**KIRKLEES METROPOLITAN COUNCIL
INVESTMENT & REGENERATION SERVICE**

DELEGATED DECISION TO DETERMINE PLANNING APPLICATIONS

Reference No:	2024/62/90907/W
Site Address:	16, Moorside Road, Honley, Holmfirth, HD9 6HR
Description:	Erection of extension to front dormer
Recommending Officer:	Joanna Rednall

DECISION – REFUSED

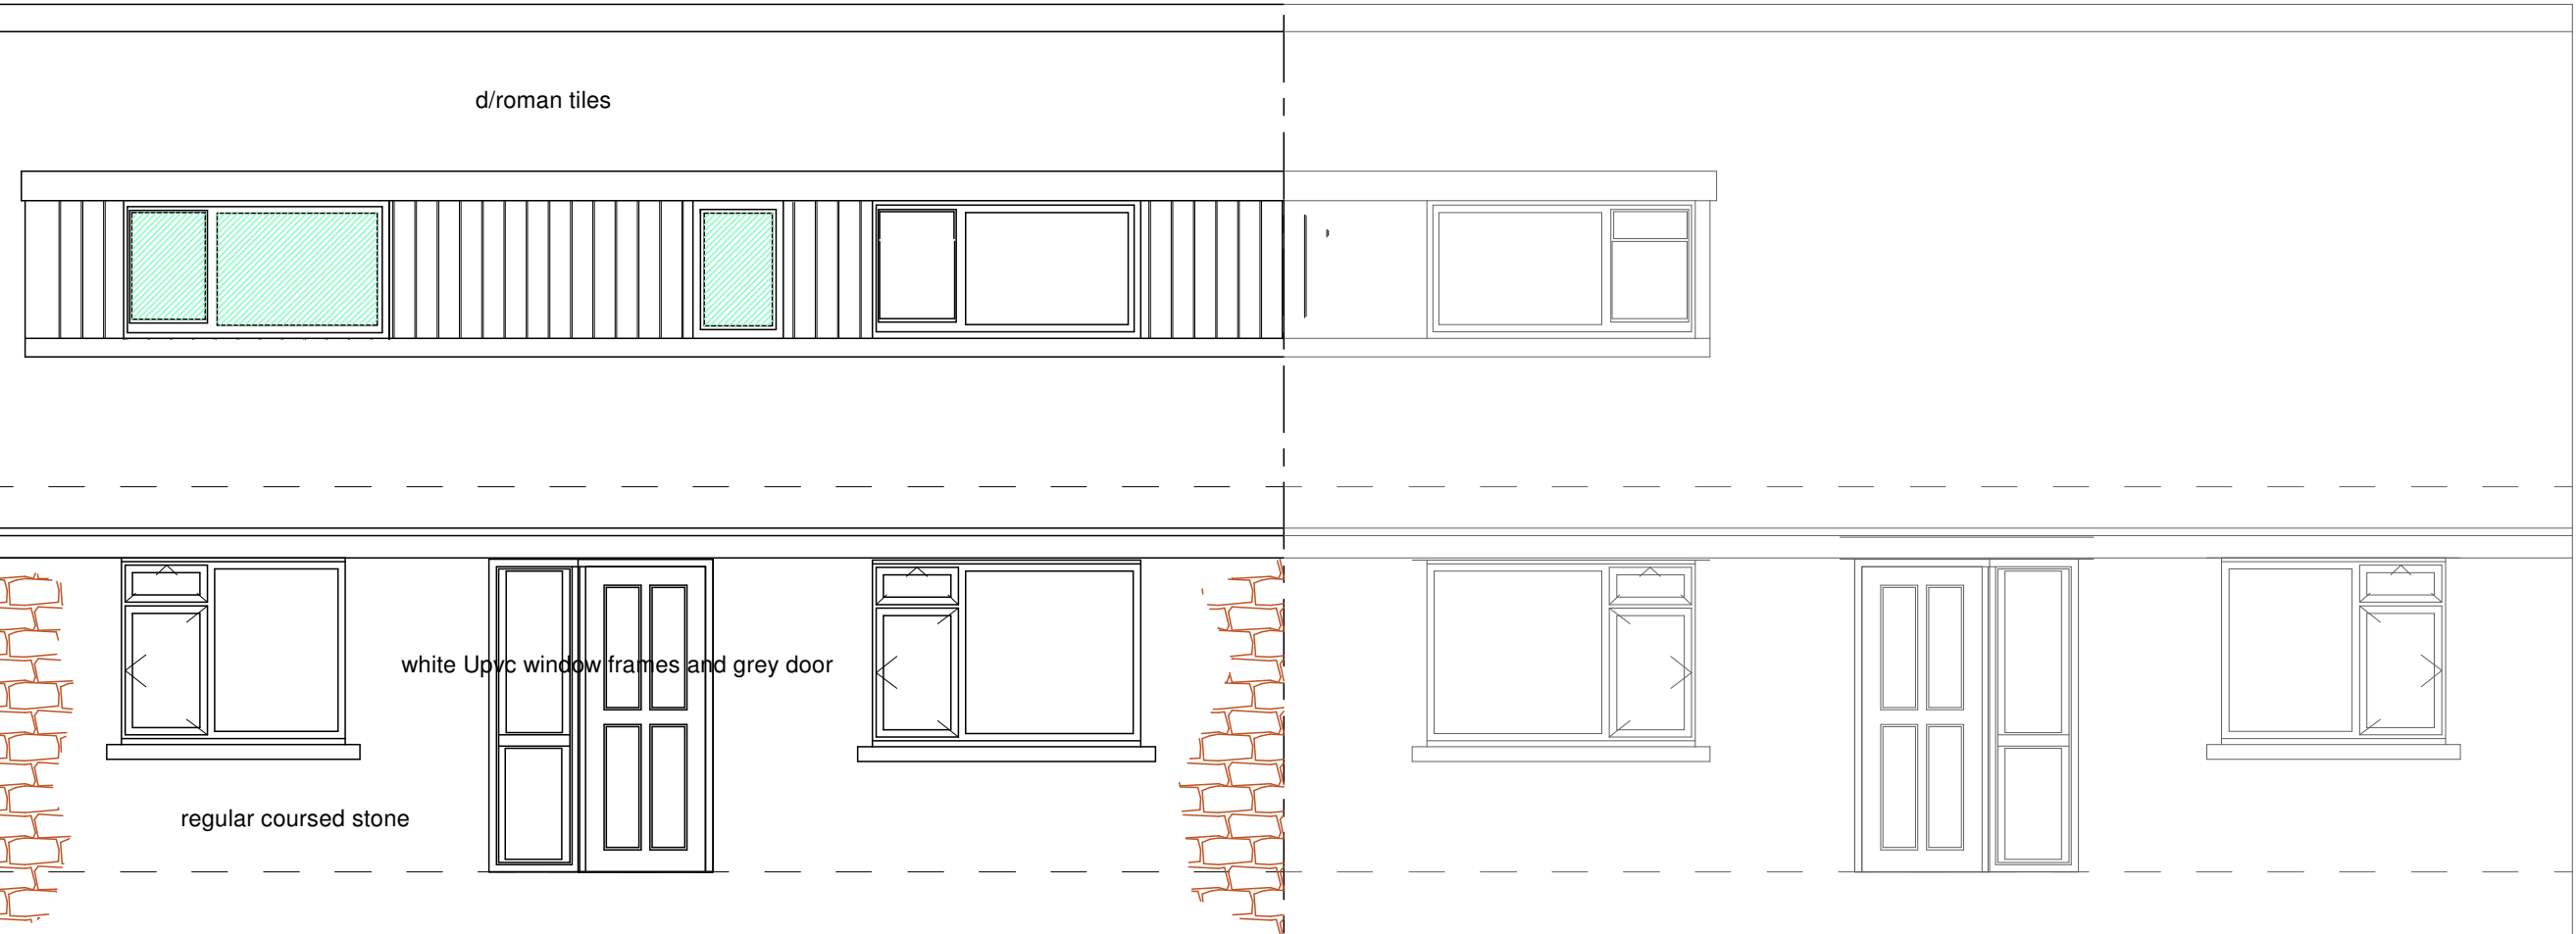
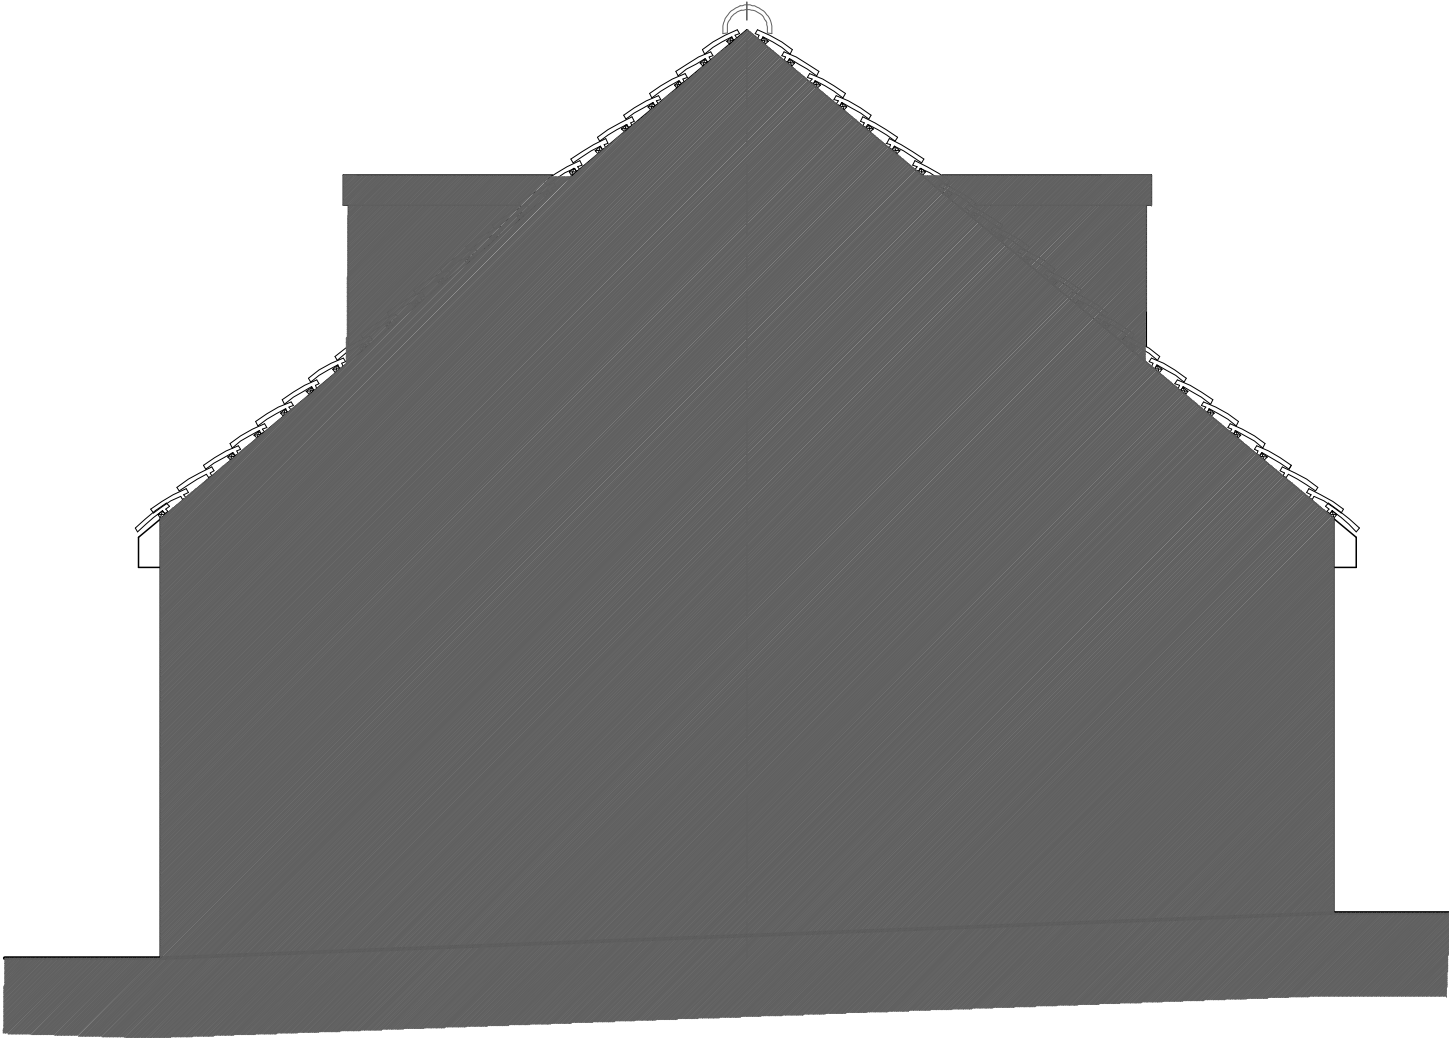
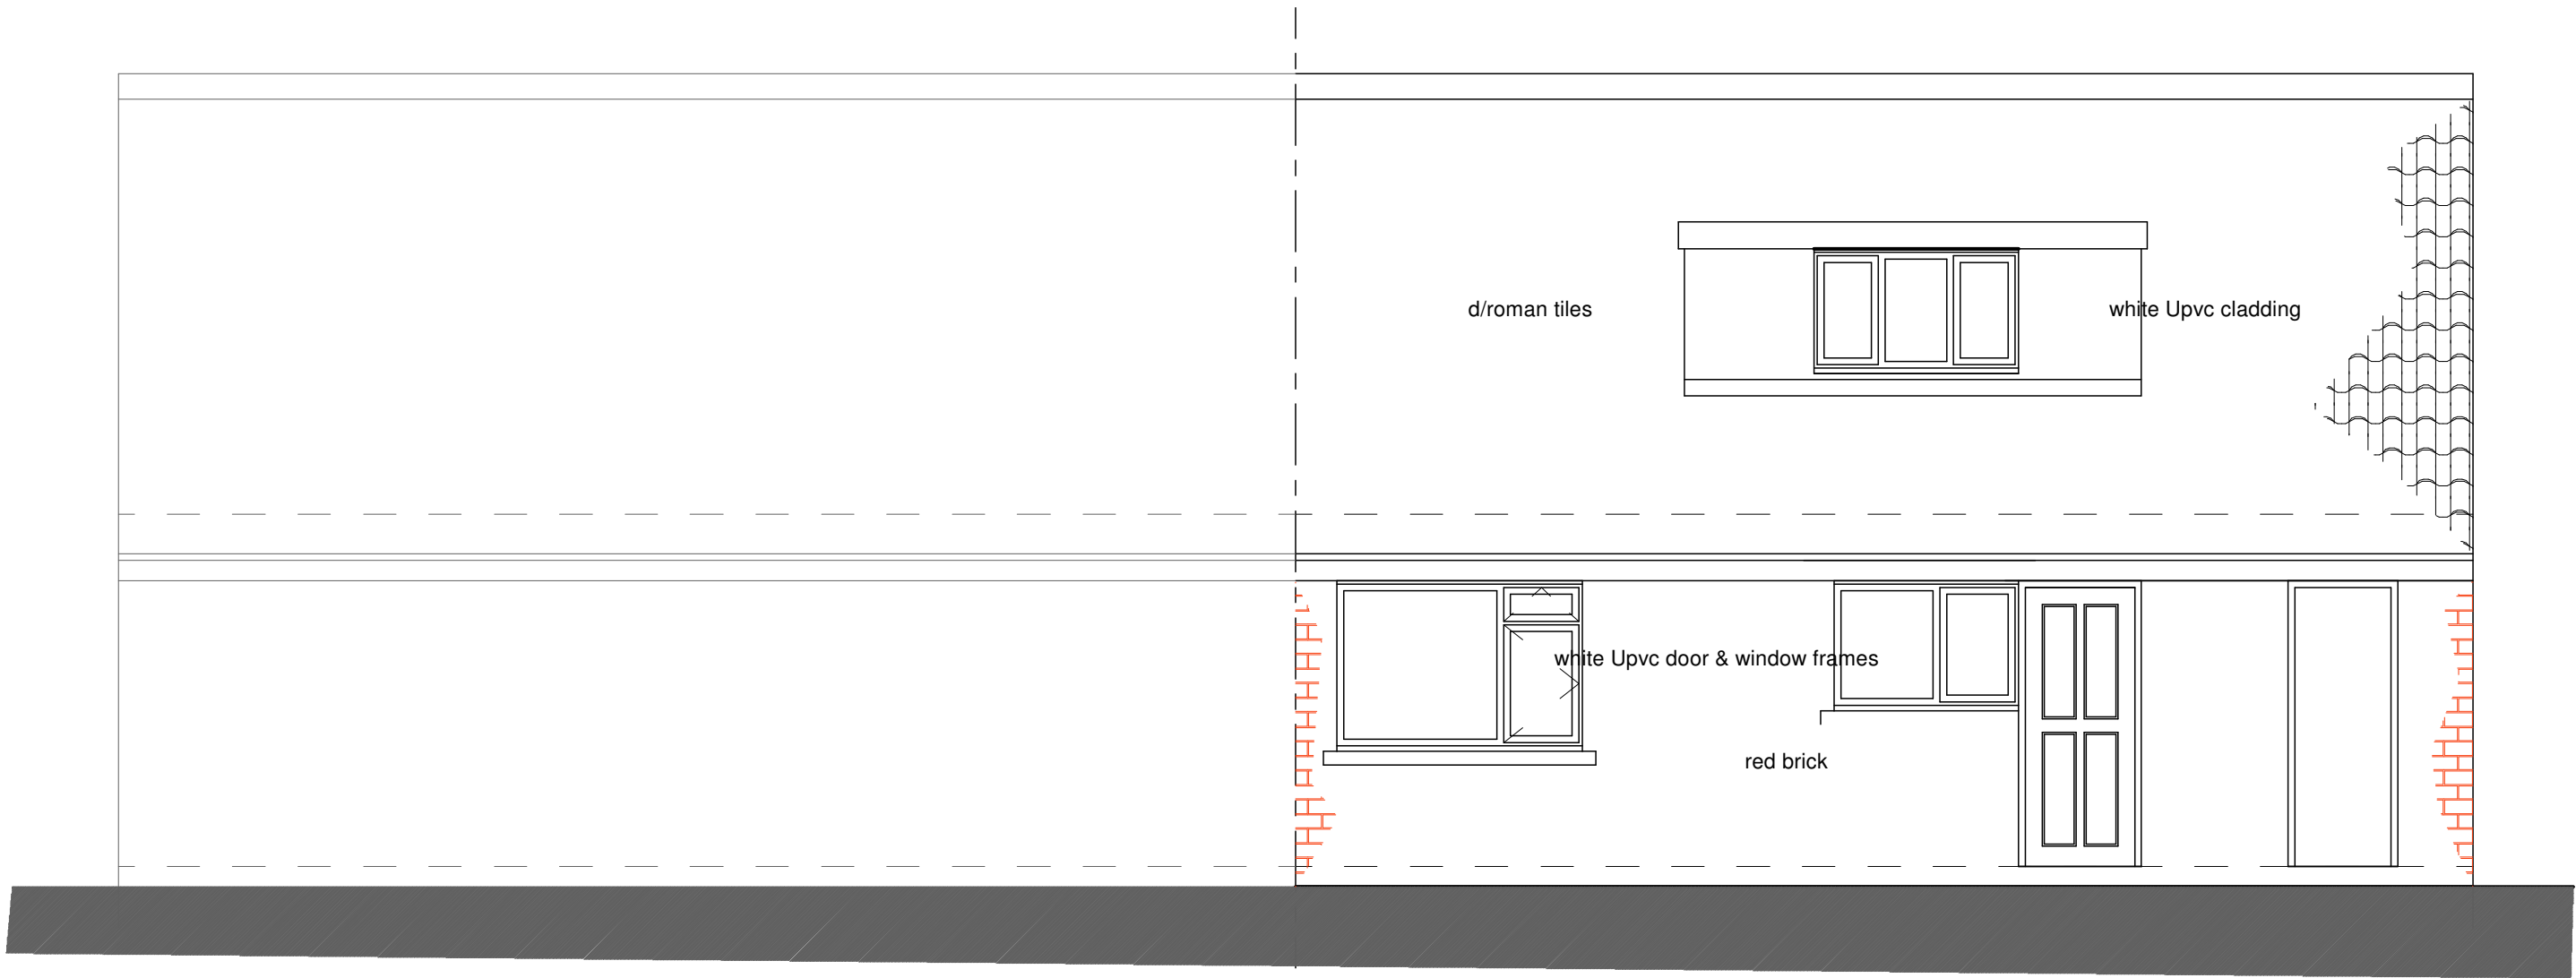
The scheme proposes an extension to an existing front dormer. The character of this part of the street scene is such that small, front dormers are relatively uniform to the roof form of each semi-detached bungalow. The proposed development would extend the front dormer by ~5.2 metres, increasing the total length of the front dormer to ~8.5 metres. The dormer would not project above the ridge of the house and is set below the ridgeline of the existing roof plane.

The amended plans saw a small scale reduction to the expanse of the dormer, with it being set in from the side elevation. However, due to the cumulative size of the dormer extension, the development would alter

character of the host property and impact upon the existing street scene whereby existing front dormers are uniform and small in terms of their size and scale. The proposal is considered to introduce alien features into the street scene where none are currently evident.

Flat roof dormers to front, within the context of the street scene within which this proposal would sit, are small scale and uniform in terms of size, design and scale. The front dormer extension would therefore result in alterations to the roof scape which would appear incongruous by introducing a large front extension into a street scene whereby there are no other such features at present.

The proposed front dormer extension, by virtue of its scale, massing and relationship with the host dwelling, would result in a disproportionate and incongruous addition to the original dwelling and would have a design that forms an inharmonious addition within the roofscape and street scene. The development is contrary to Policy LP2 and LP24 a) and c) of the Kirklees Local Plan, Policies 1 and 2 of the Holme Valley Neighbourhood Development Plan and Policies contained within Chapter 12 of the National Planning Policy Framework.
